Final Report - Corrections Required **Application No. ZONE-25-0021**

Record Type : Zone Change

County File: OAR2512 – Banning Lewis Ranch Village C – Review 2

City File: ZONE-25-0021

ISSUE RECORD

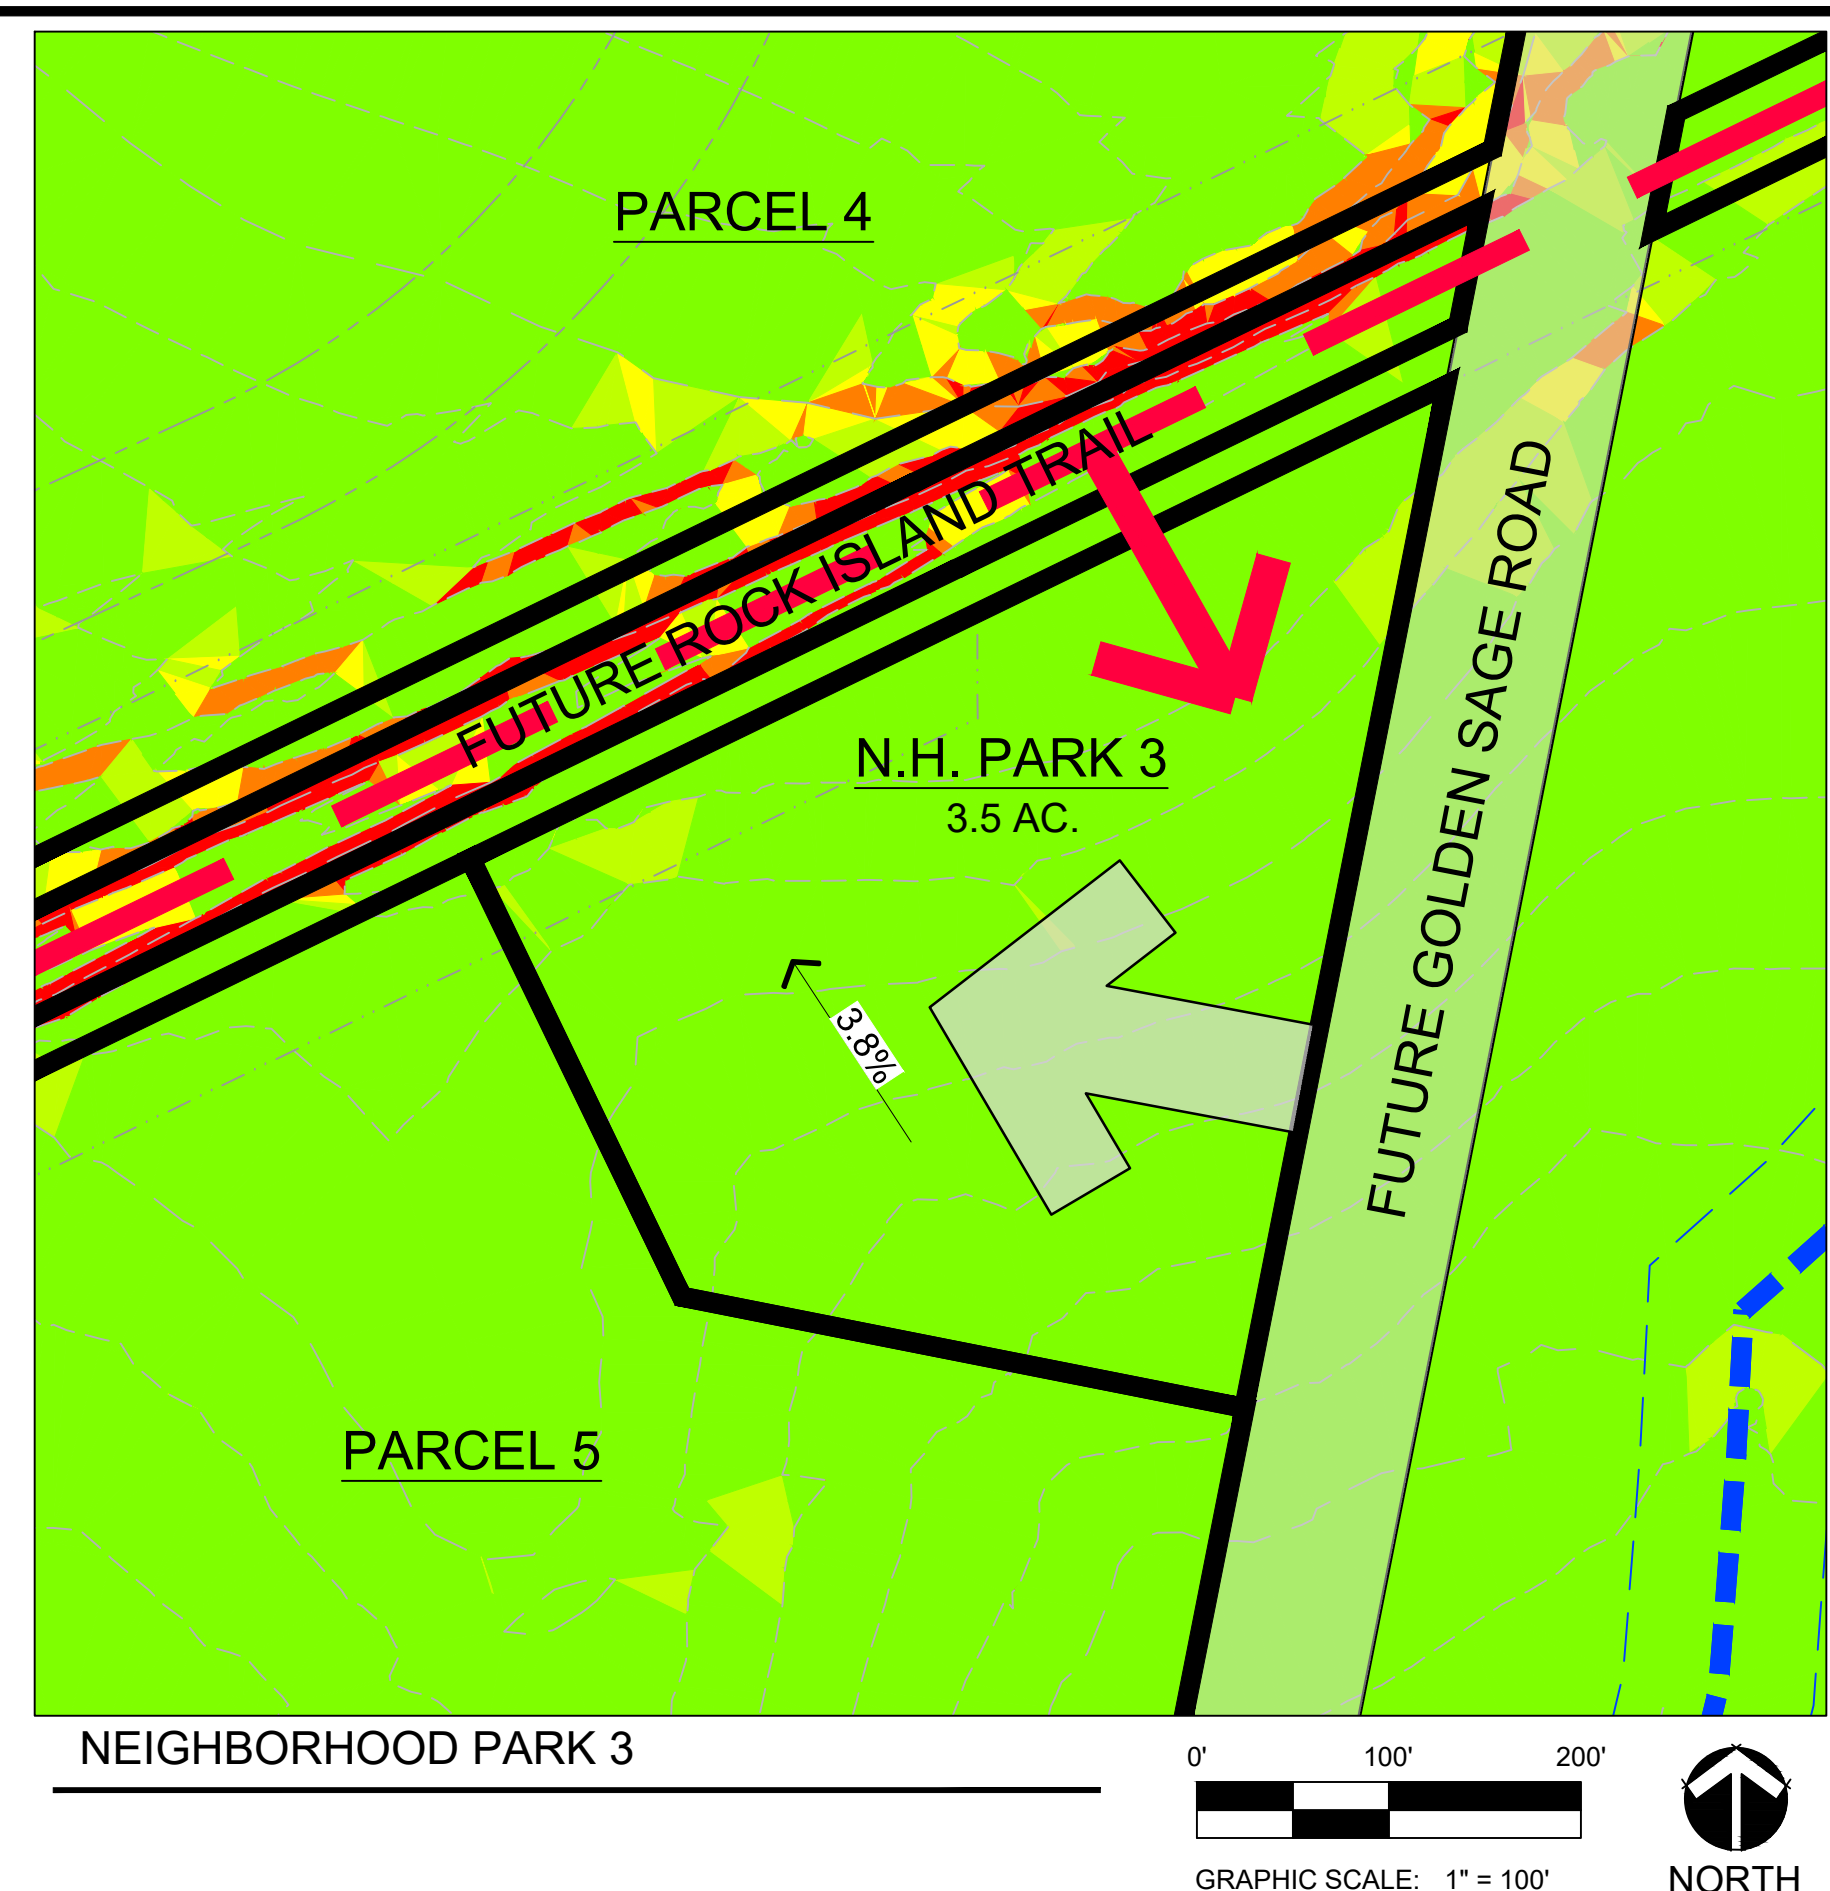
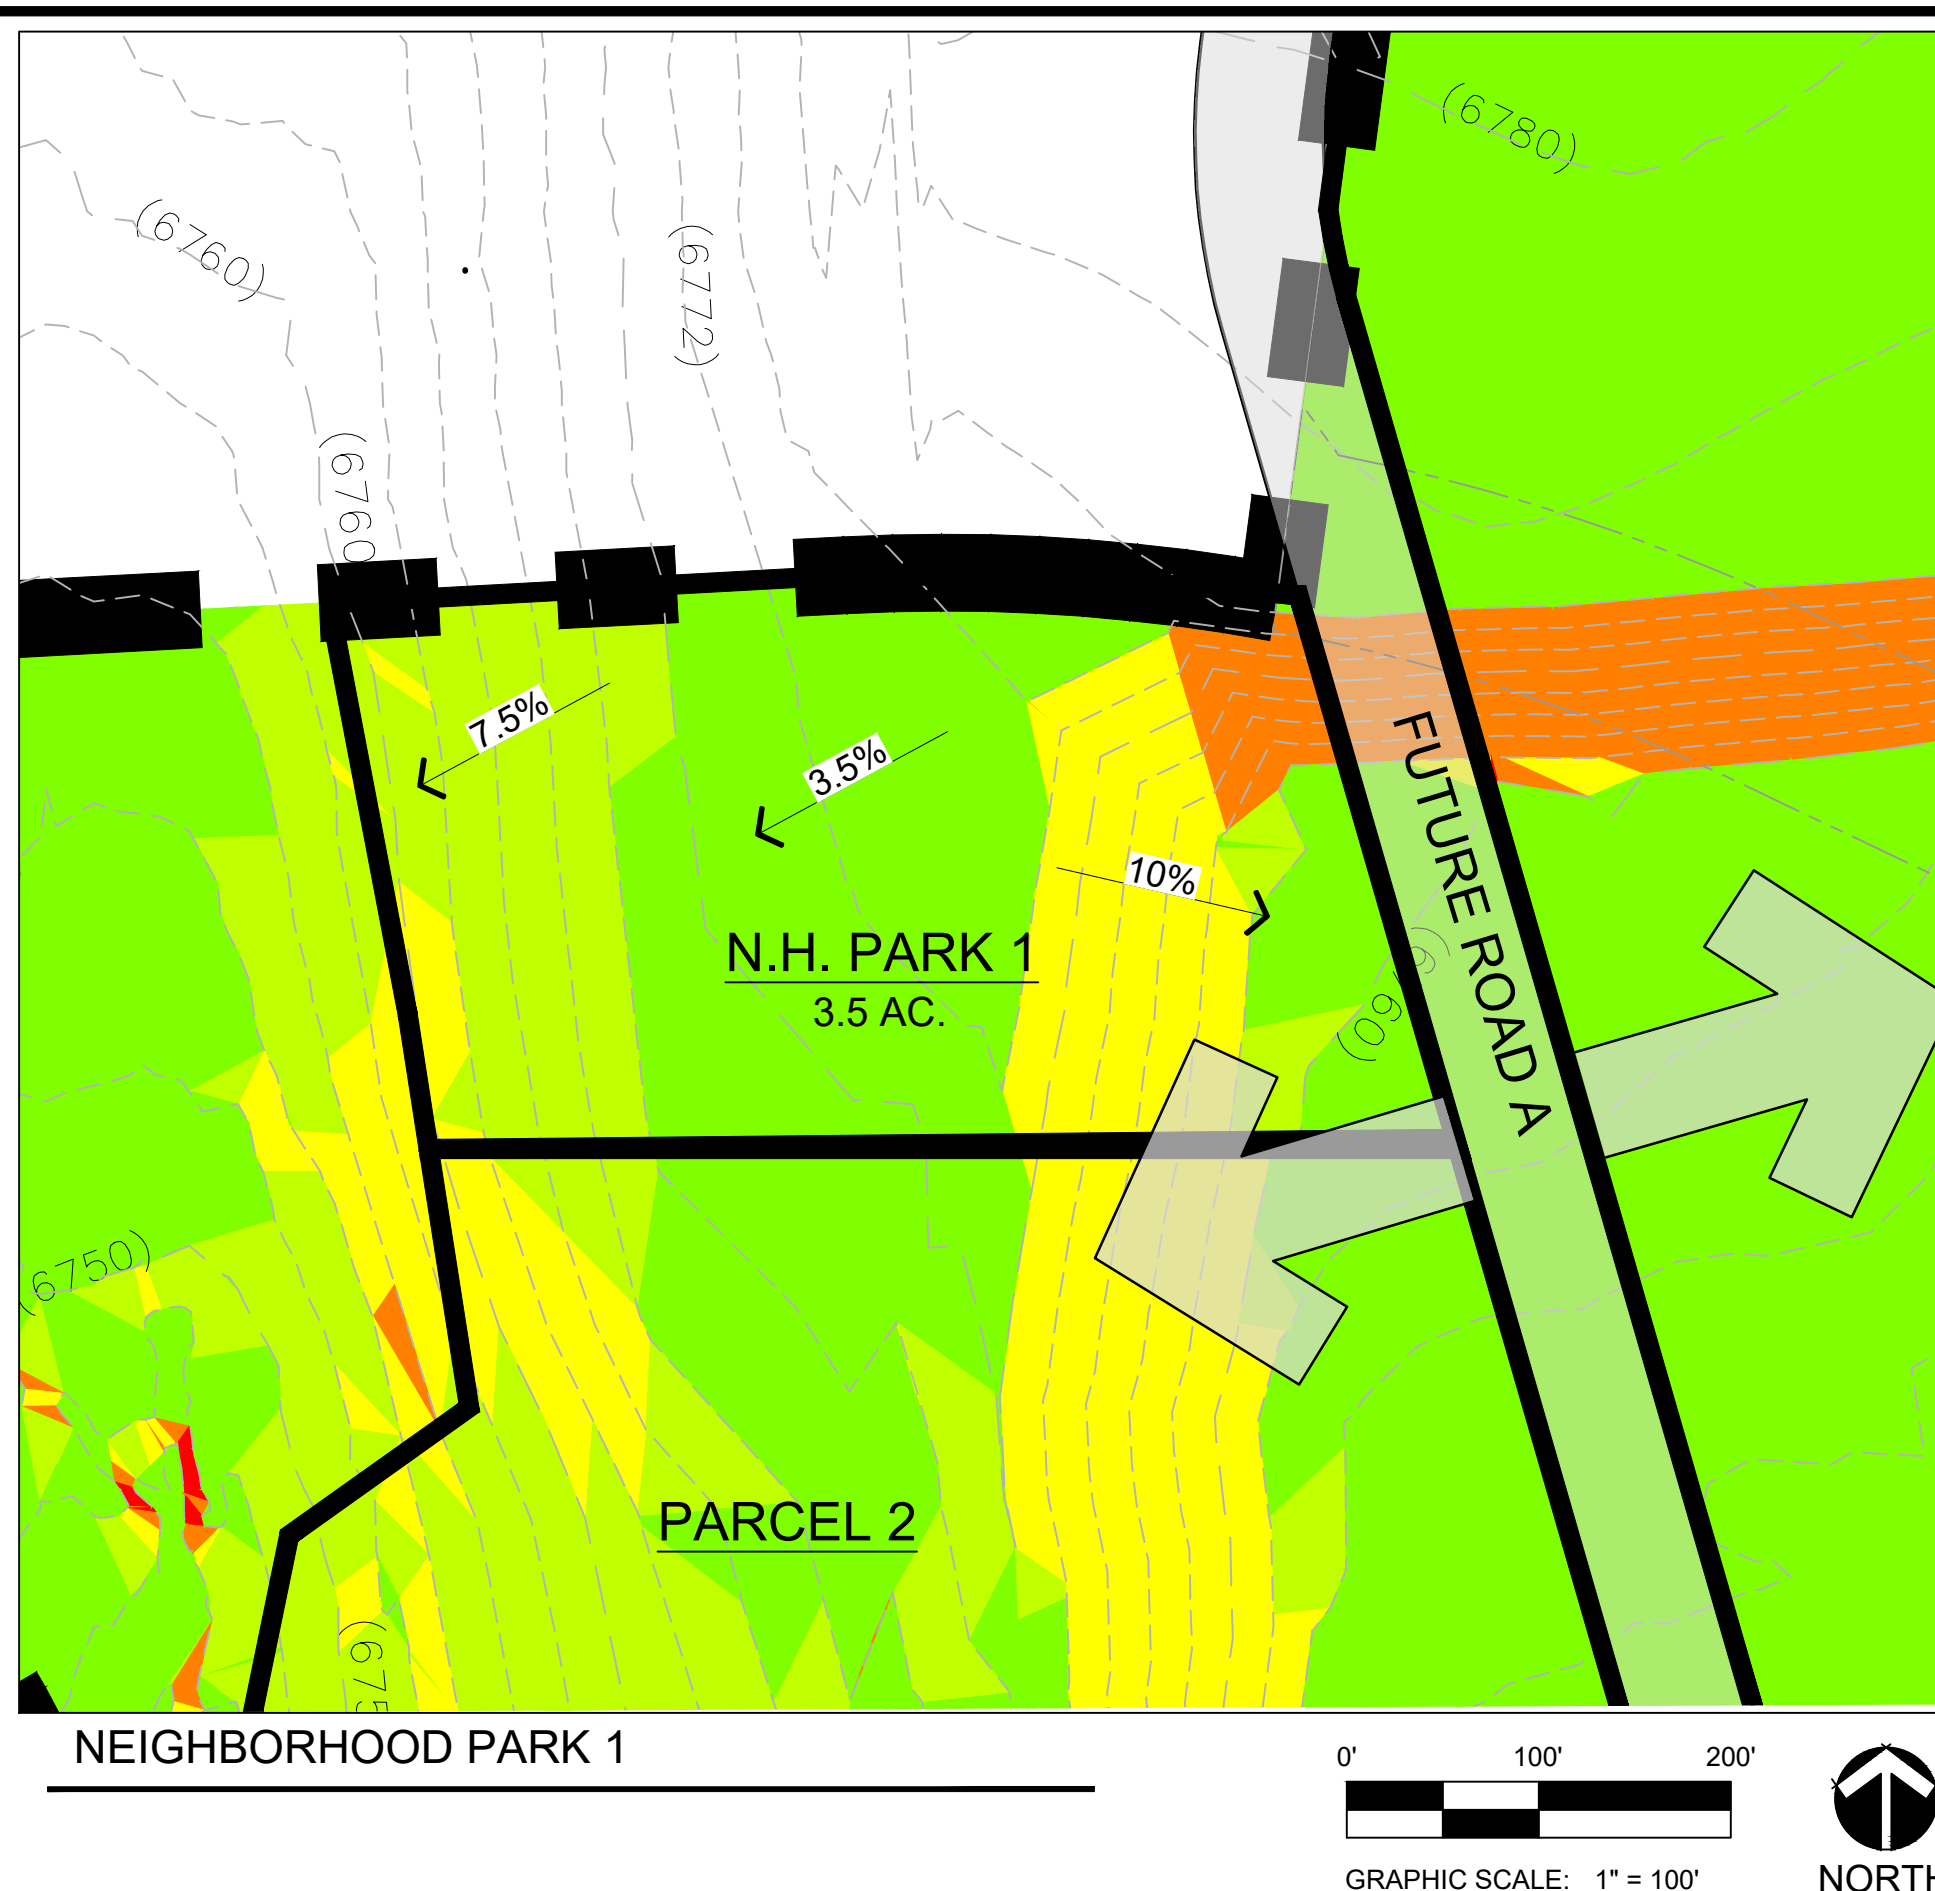
Comment ID	Reviewer : Department	Review Comments
20	Chris Padilla : COS Airport	Action Items: 8/4/2025: This action item was approved by the AAC, please provide proof of Avigation Easement. This item will be reviewed by the Airport Advisory Commison on 7/23/2025 with the below action item for Parcel # 5300000733. • Avigation Easement: An avigation easement is required or provide proof of previous recording (book/page or reception number). Add avigation easement note to plat.
